Your ref:
Our ref: 21/00541/LDP
Please ask for: Mrs Lesley Raby
Direct dial: 01553 616818
Direct fax: 01553 616652
E-mail: borough.planning@west-norfolk.gov.uk

Details: **Lawful Development Certificate: Removal of conservatory, provision of new orangery extension and garage conversion to form bedroom at 12 Kestrel Close Burnham Market King's Lynn Norfolk PE31 8EF**

LOCATION PLAN SCALE 1:1250

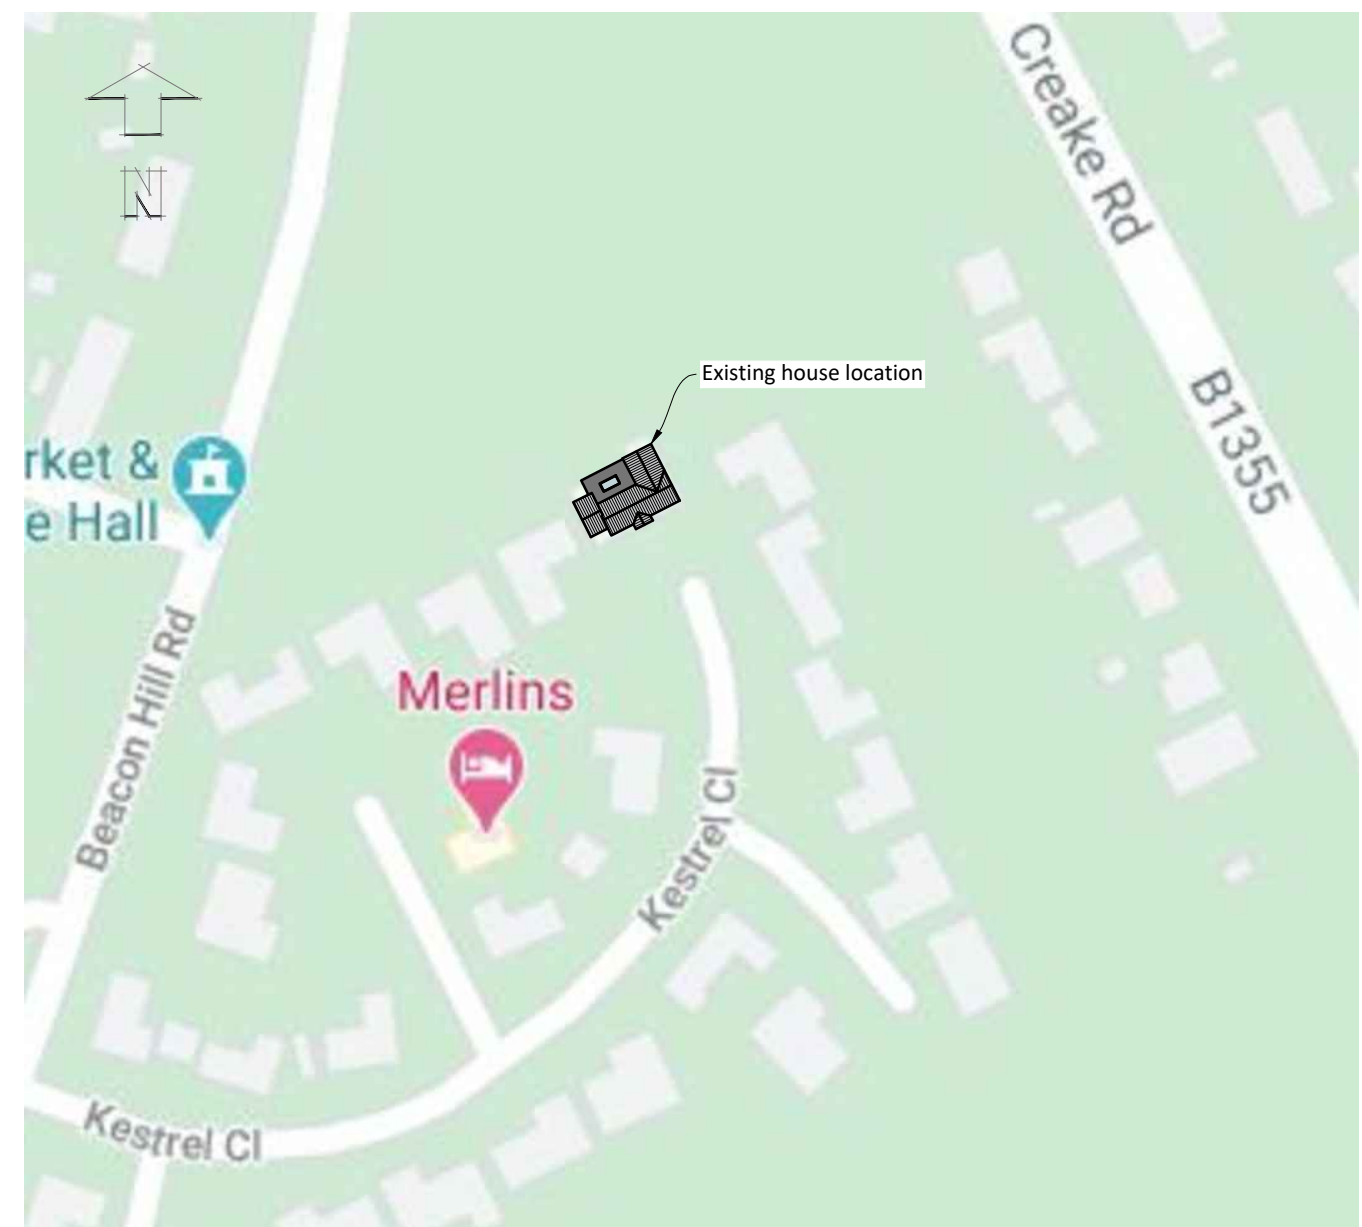
1. Outline the application site in red on the location plan around the residential boundary.
2. The proposed plan shows double doors to the east on the floor plan which are not shown on the elevation.
3. The site address and the map appear to refer to 12 Kestrel Close but the applicant address is at 10 Kestrel Close is this correct.
